Our Ref: F/6/18/HH
Your Ref:

Town & Country Planning Act 1990 (as amended)
Town & country Planning (Development Management Procedure) (England) Order 2015
Application for Planning Permission for Works or Extension to a Dwelling

Development Demolition of existing garage, single storey rear/ side extension & new pitched roof over existing front porch.

Location Southfields Burndell Road Yapton

Roof Plan Scale 1:100 @ A1

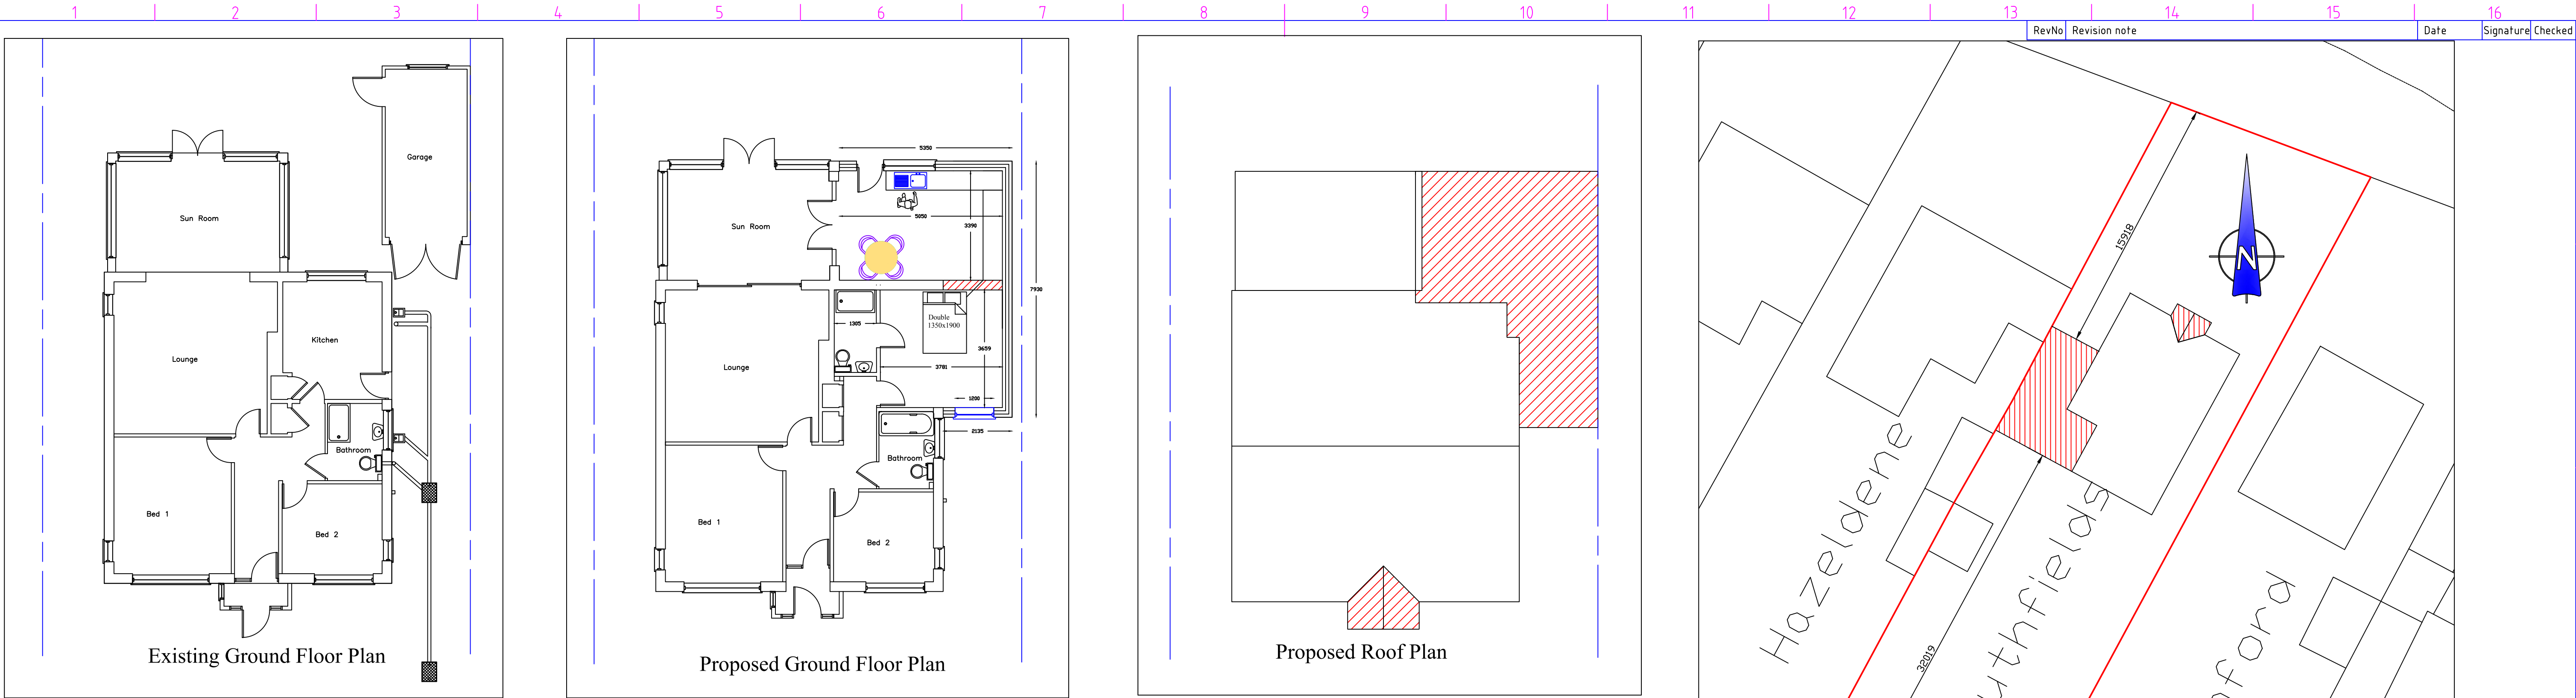
Please show the proposed front porch pitched roof on the proposed roof plan.
